**Ref: Planning Application R/90/18/HH
at no: 9 Park Drive, Rustington**

Further to the applicant's earlier applications, ref nos: R/283/17/HH and R/90/18/HH, and having inspected the details and plans of the applicant's further revised proposals as shown on the Council's website I am writing to object to the latest version of the planning application for extensions to the existing buildings at no: 9 Park Drive, Rustington.

203 Proposed East Elevation

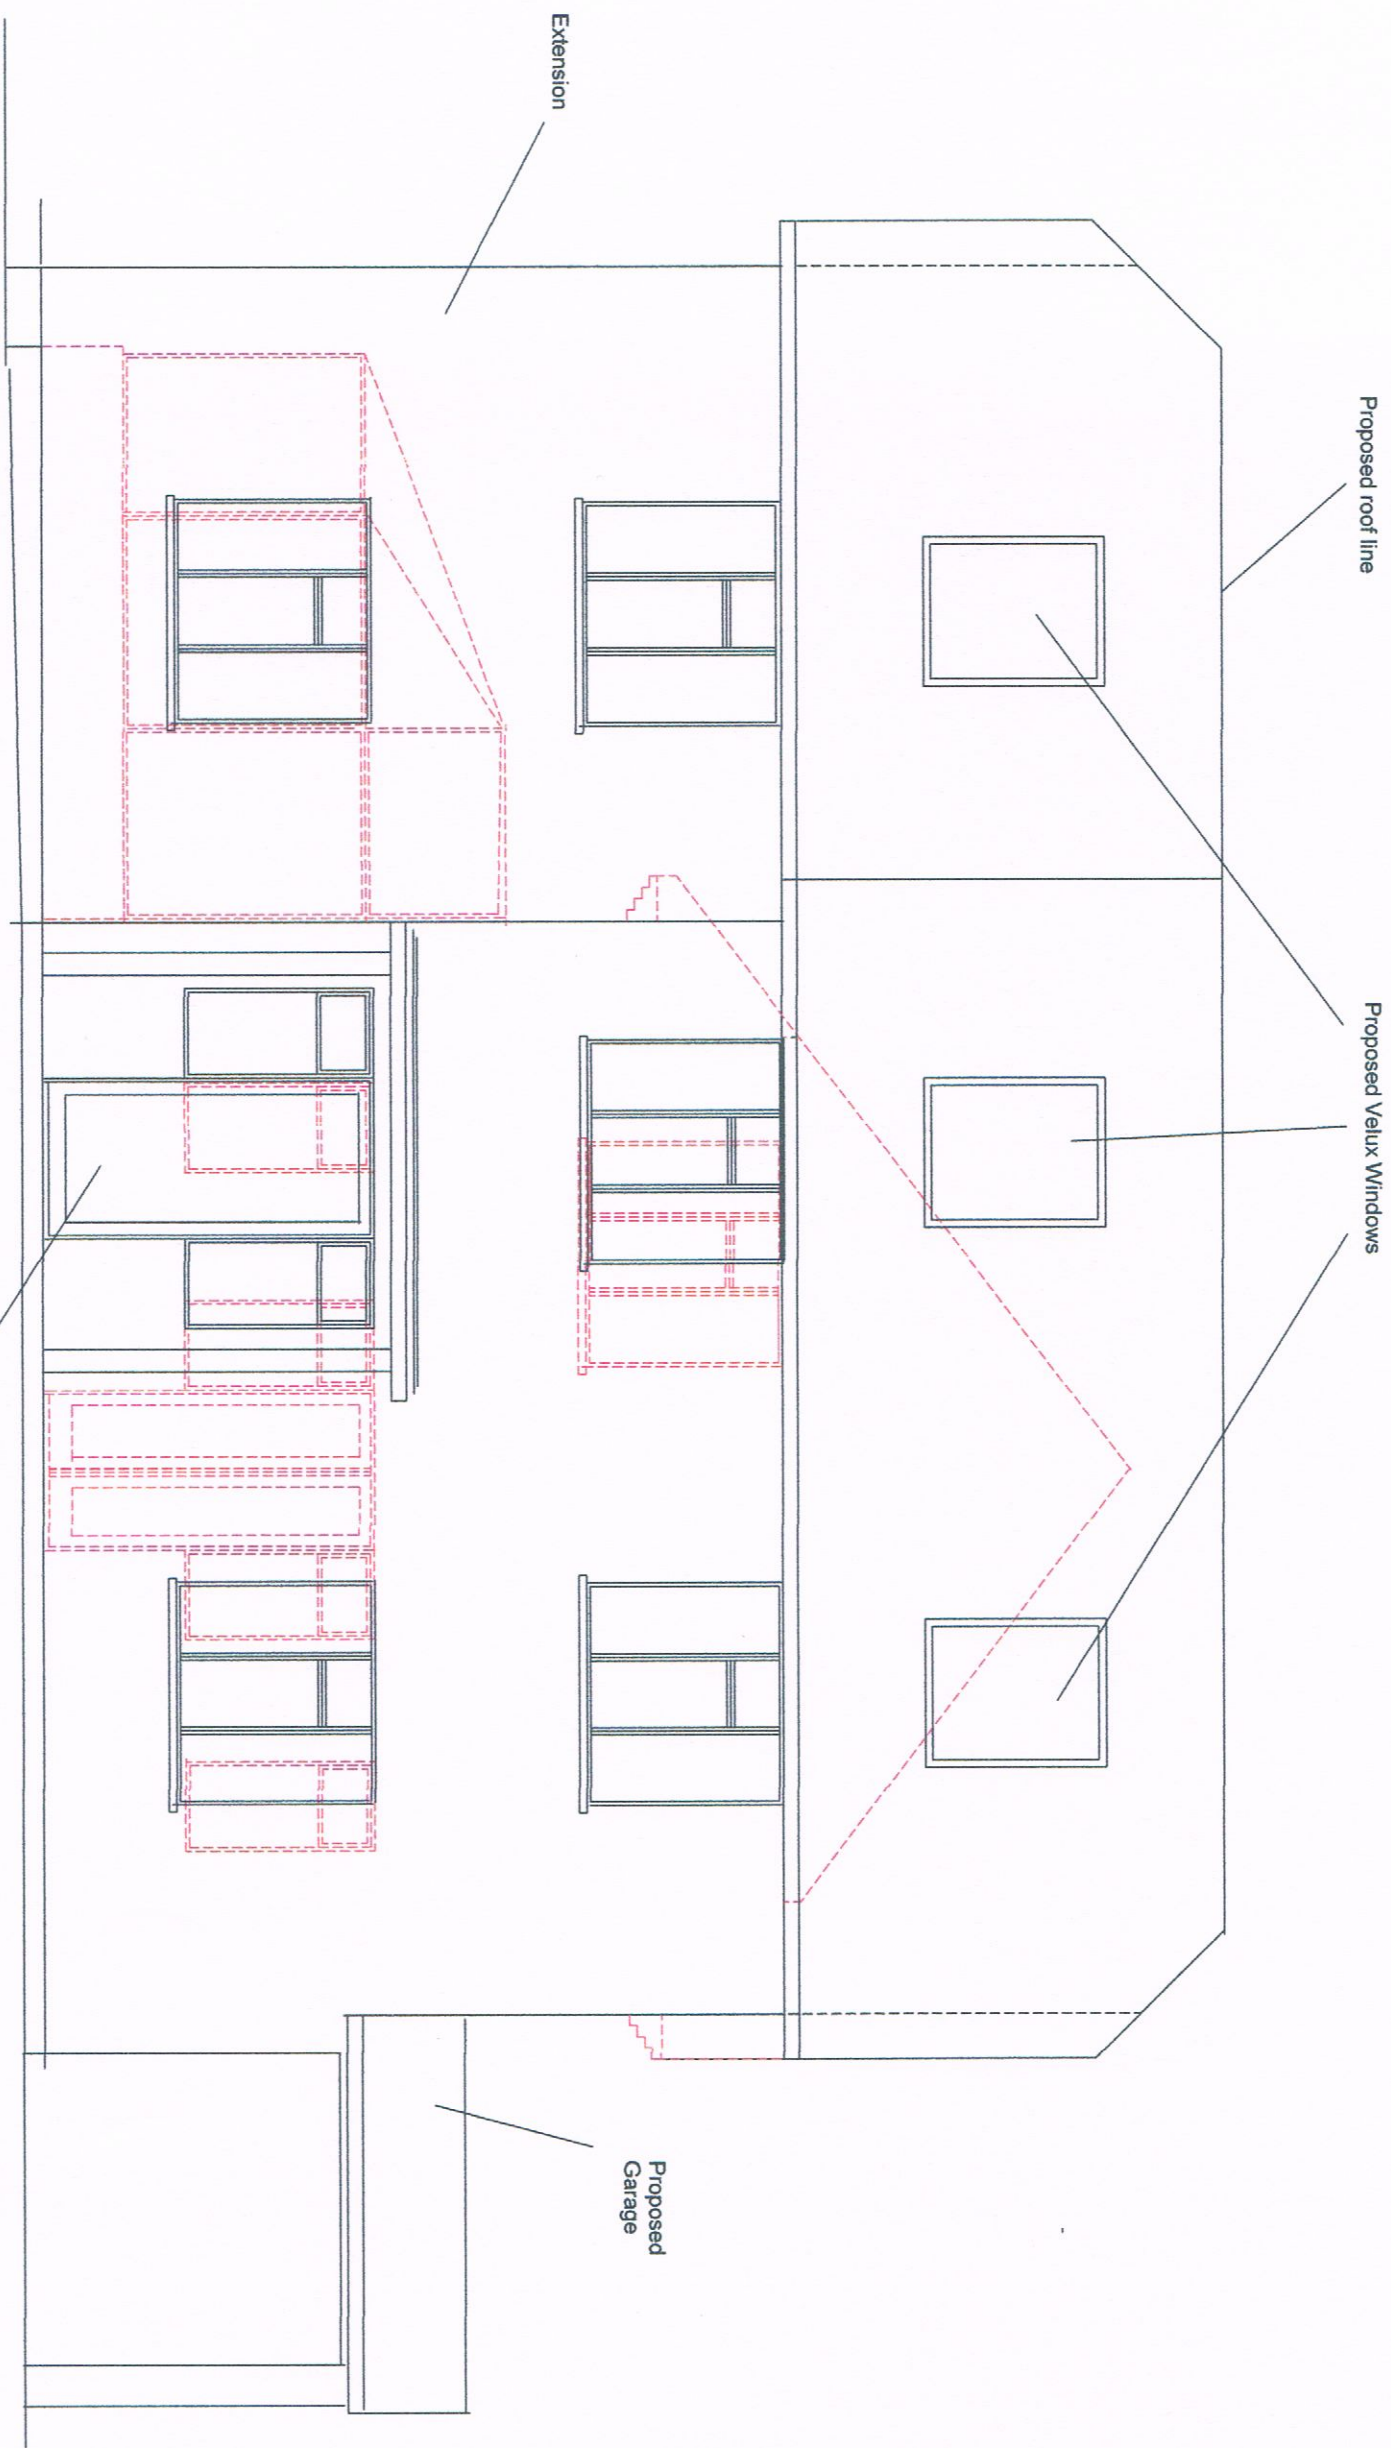
- (ii) Visual subservience to the existing building – the front, ie east, elevation of the proposed house shows that despite the further hipping of the gable ends the proposed building has an area of some 35% more than the existing building. Such a major enlargement cannot be said to be subservient to the existing building. Further it is difficult to envisage how any three storey extension of this magnitude could ever be seen as visually subservient to the original property.

- (iii) Overbearing effect and appearance – the greater area of the roof over the longer re-orientated roofline axis will present the appearance from the street, Park Drive, of a significantly larger frontage to the extended house than the existing one. The full height above the former conservatory, even with a larger hip, will similarly present an overbearing appearance to those looking at the now much closer gable end of the extended house from their flats on the northern side of Herne Court.

Further the sheer scale of the development with its habitable rooms and three windows in the roof, back and front, would be overbearing and its eastern elevation would be intrusive to the neighbours on the opposite side of Park Drive, and its western elevation intrusive to those in St Anthony's Way.

- (iv) Relation to established spatial character and pattern – the three windows in the roof at both the front and rear of the proposed extension create both the fact and the appearance of what would be the only three storey house in the road. The extension would create a house that was wholly out of character with the rest of the properties in this part of Park Drive. Indeed the mass of the enlarged building would amount to an over-development of the site.

Proposed Ground Floor Plan

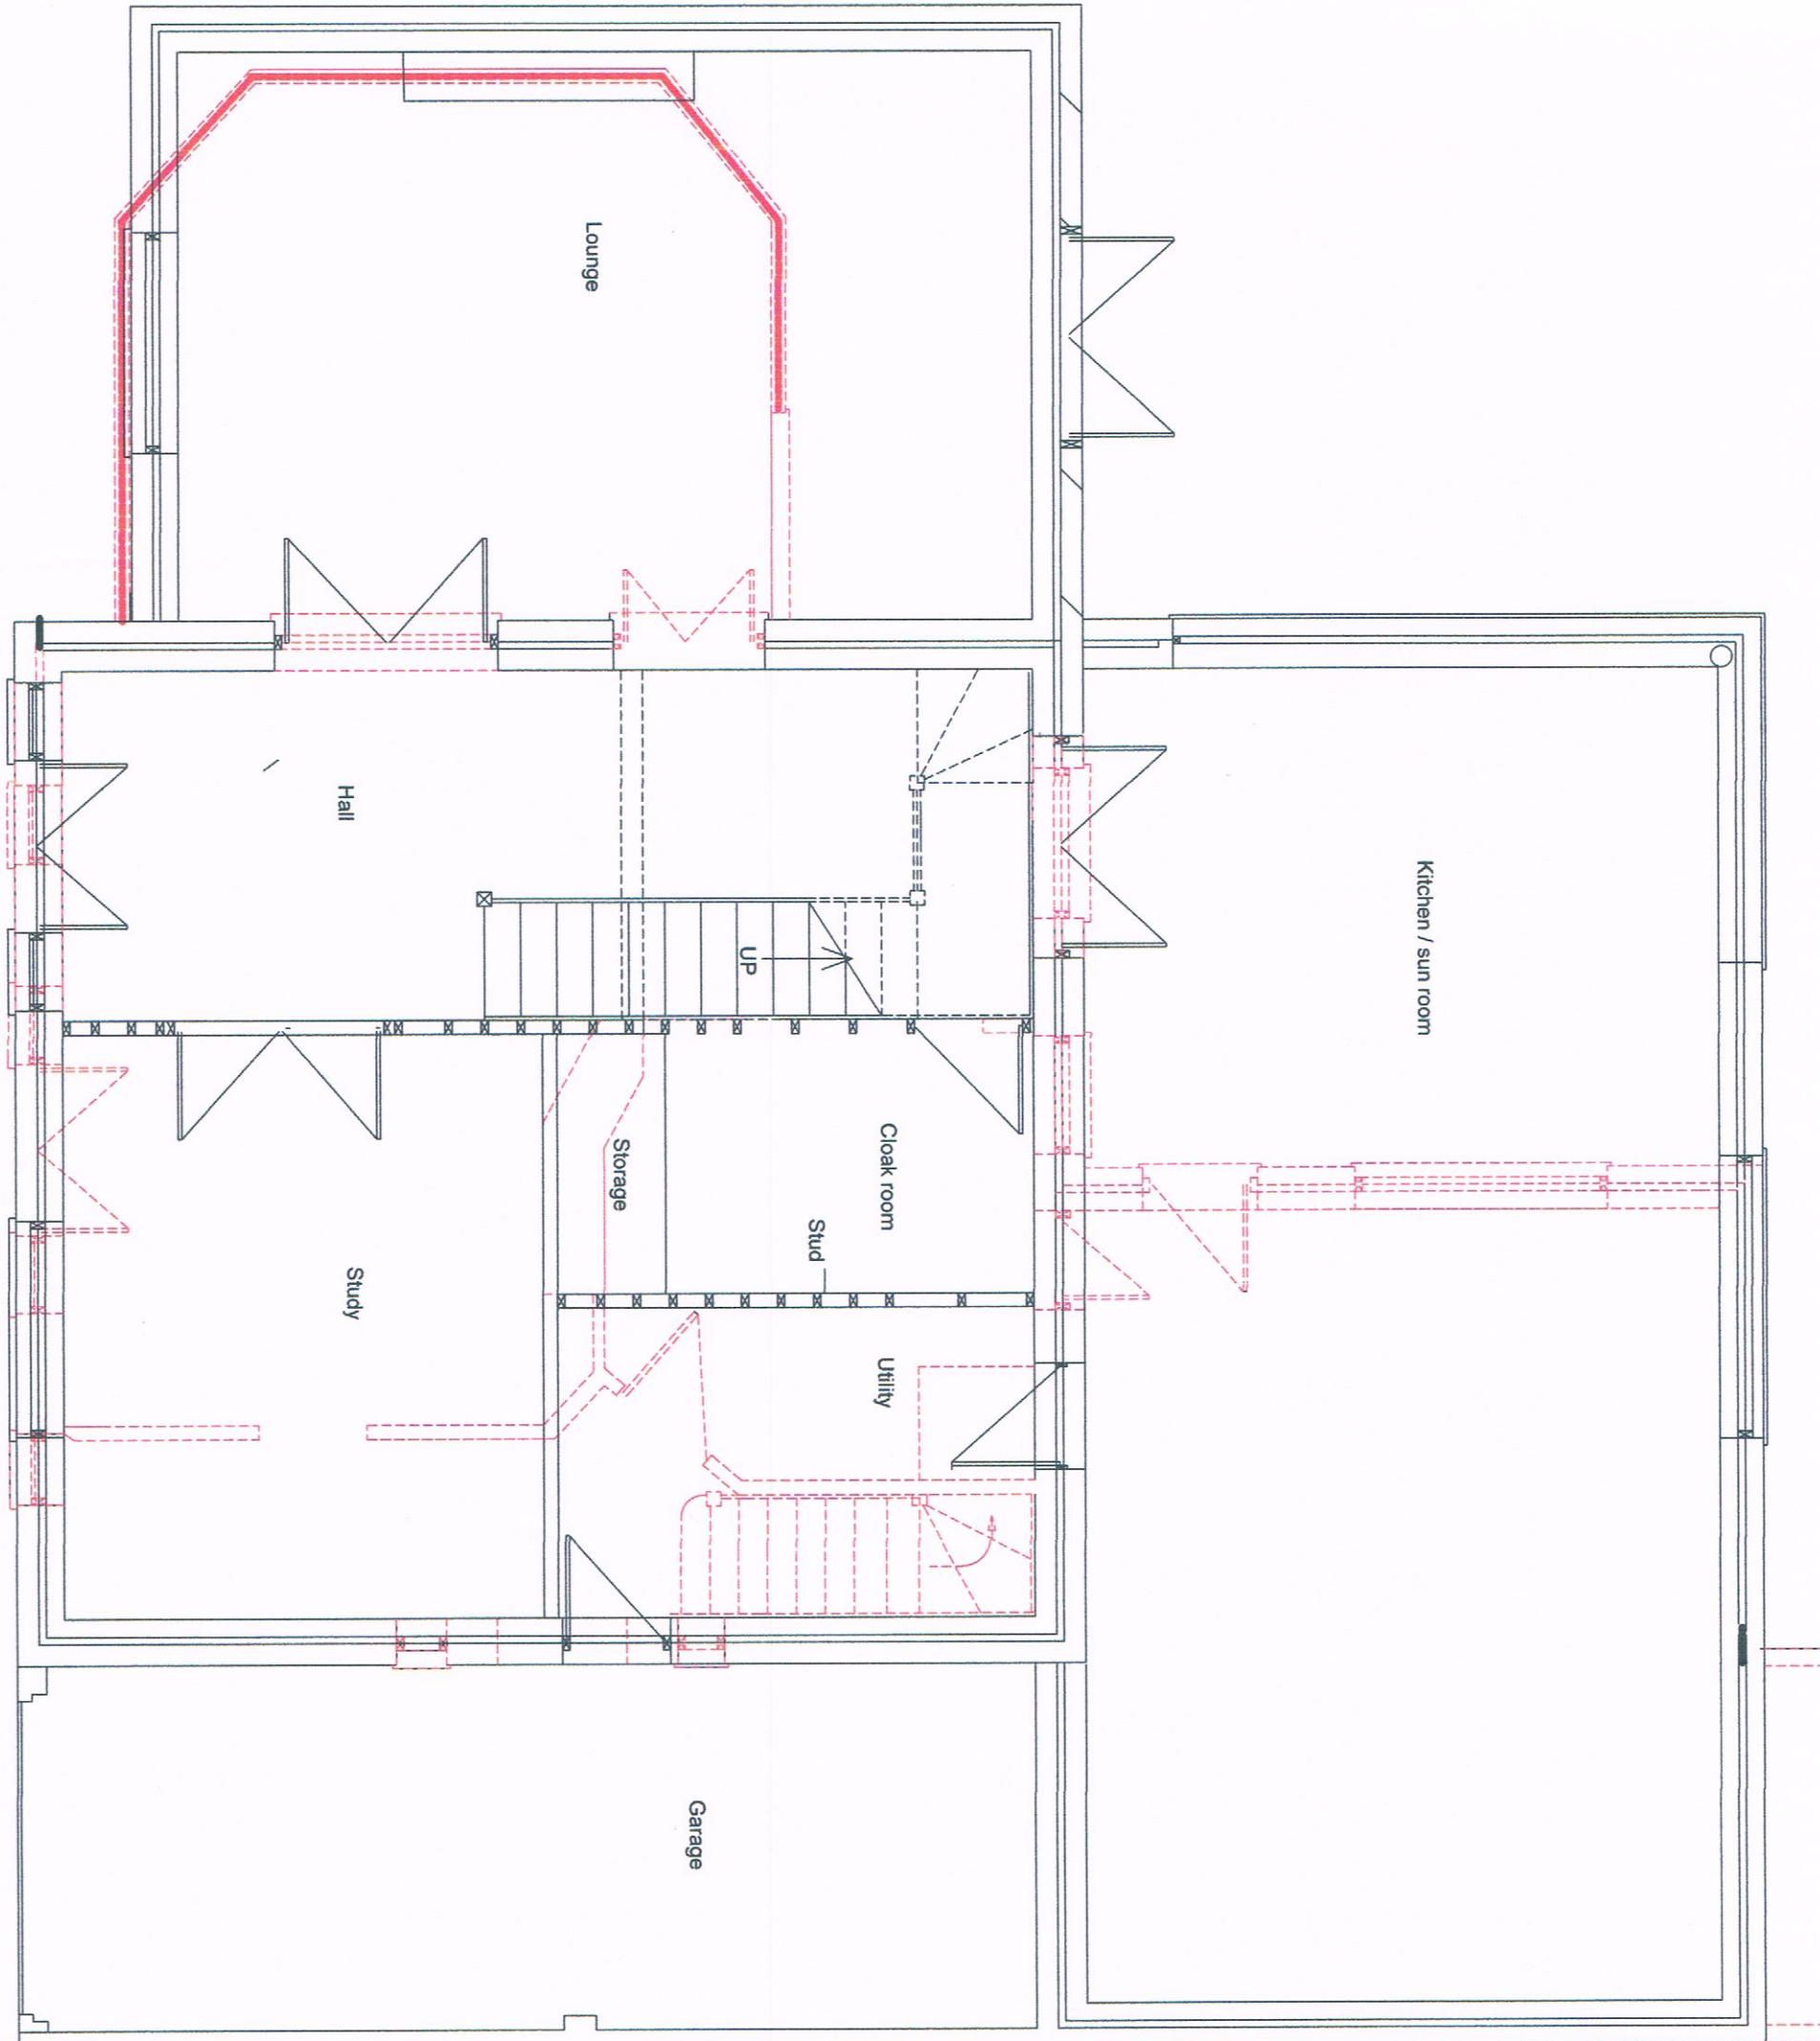
- (v) Parking – the plans of the extended property still show just a single garage and neither the plans nor the Application details provide any indication of the level of provision for the parking of cars or bicycles which will be made for what will become a five bedroom house. It is pertinent that no extra garage facilities are proposed because the existing garage has width for only small vehicles and does not conform to the dimensions now expected of a garage.
